24 January 2012

Proposed Modification to Approved Major Project No. 09_0051 – Centre for Obesity, Diabetes & Cardiovascular Disease

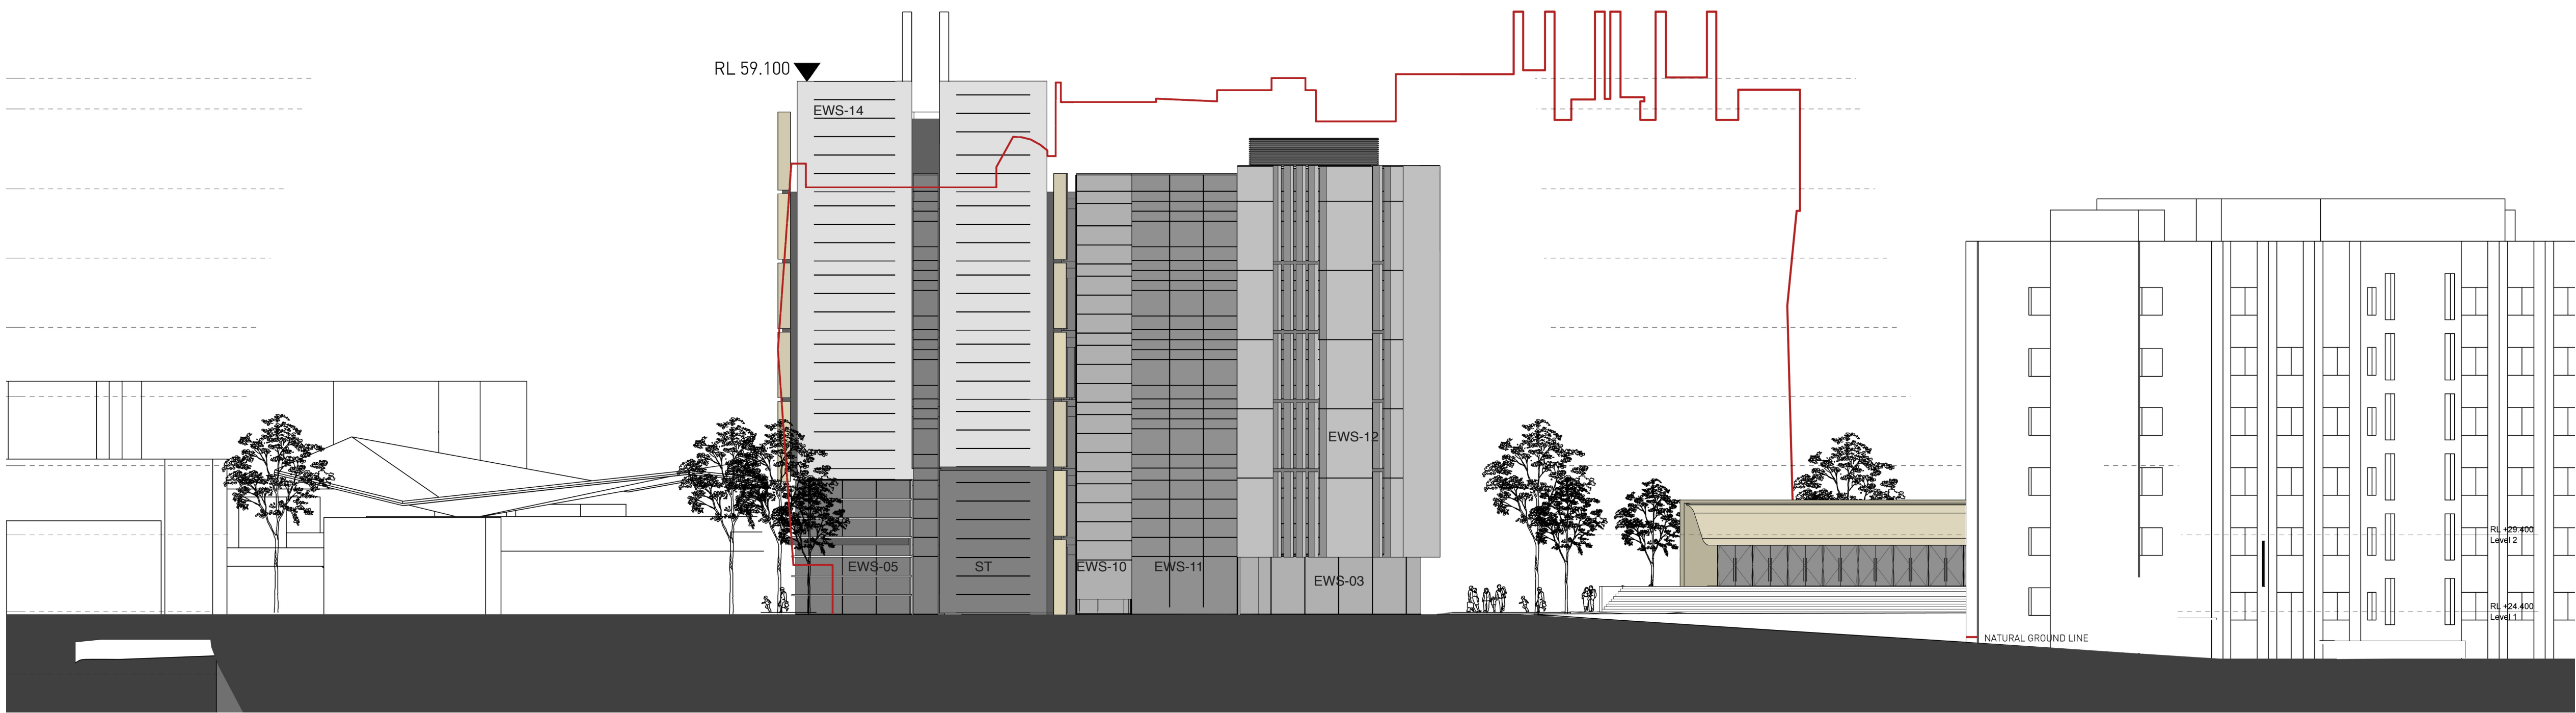
Overall design refinements and adjustments were made by FJMT to the north-west sandstone façade in response to Council's comments regarding the relationship to St John's College. The major changes are outlined as follows:

- Introduction of an offset in the sandstone facade at the major vertical circulation 'slot' to reduce the apparent visual bulk of the envelope and to appropriately scale the façade in the context of St John's College.

- Introduction of two additional vertical 'slots' – slightly narrower than the major slot – in the elevation breaks down the length of the façade and relates closer to the proportions of a wing of St John's College and further adds façade surface articulation. These slots reflect the internal function of building as they are mechanical risers.

- Further refinement of the proportions, changes to the rhythm and adjustment of the locations of the vertical slot windows in the sandstone façade to align with interior function/design.

- At the North-West corner of the building, the glazing at ground level is extended further above by raising the sandstone element further to acknowledge the presence of St John's and improve the visual permeability in this area.

- Refinement of the north-west building parapet to step down at the major vertical slot to mitigate the apparent length of the building façade in relation to the context and reflect the topography. The roof plant is also set back to visually mitigate the height as well as being fully screened.

- Introduction of a solid metal facade at Level 1 (Ground) to reflect internal functions (seminar rooms). This assists in providing a recessed base to the sandstone façade. Cladding will be feature vertical louvre/slots and appropriately detailed joints to avoid a blank appearance.
